KIRKLEES METROPOLITAN COUNCIL INVESTMENT & REGENERATION SERVICE

DELEGATED DECISION FOR DISCHARGE OF CONDITION AA.2(3) - NOTIFICATION OF ENLARGEMENT OF A DWELLINGHOUSE BY CONSTRUCTION OF ADDITIONAL STOREYS

Reference no. 2024/CL/90706/W

Site Address	38, Thornton Lodge Road, Thornton Lodge, Huddersfield, HD1 3JH
---------------------	---

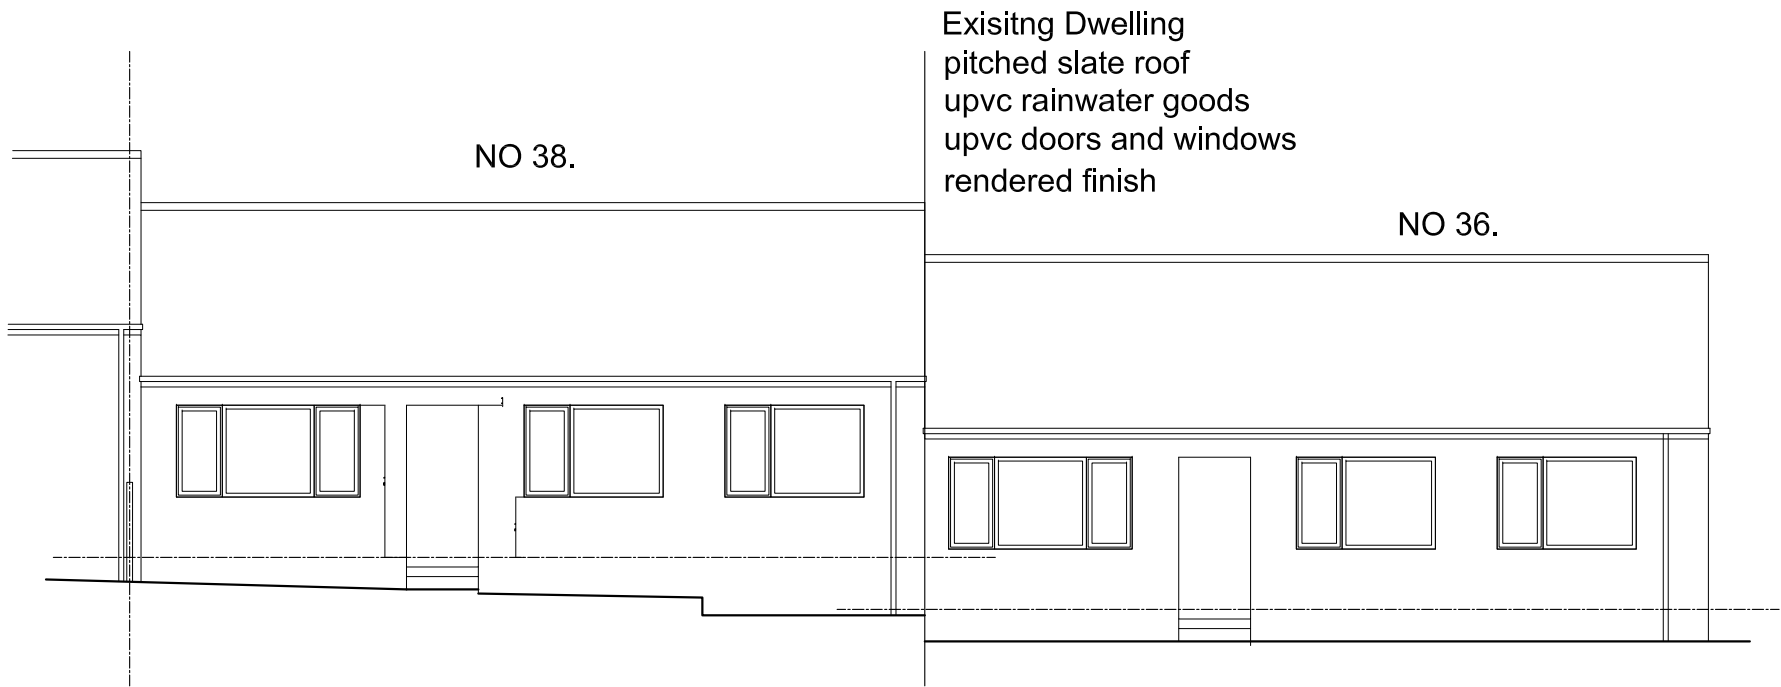
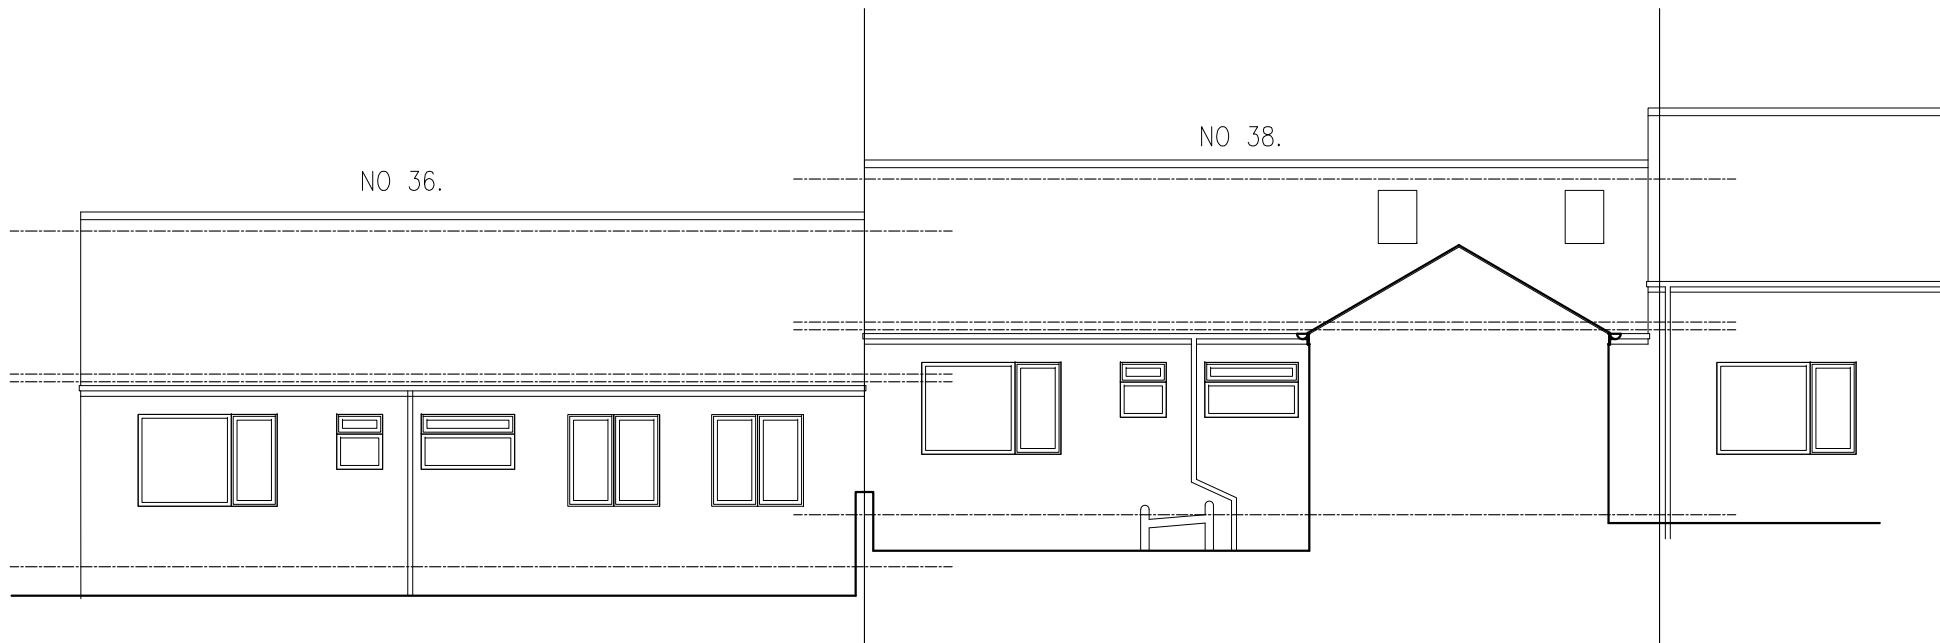
3.1 The applicant proposes an additional storey to the existing building. The drawings indicate that the height of the eaves would be increased from approximately 2.8m to 6.7m and the ridge would be raised from approximately 5.1m to 8.8m. Therefore, the eaves and the ridge height would be increased by approximately 3.9m and 3.7m respectively and therefore exceed the height requirements of the regulations which state that:

3.2 In this instance no. 38 is adjoined to nos. 36 & 40 and therefore a terraced property where no. 36 is currently stepped down in height by 0.6 metres. The resulting step down, taking into account the sloping nature of the site and when measuring from the highest ground level adjacent to each property results in the resulting height of no. 38 (8.8 metres) exceeds in the existing height of no. 36 (5.1 metres) by 3.7 metres thus contrary to sub-paragraph (g) of Class AA.
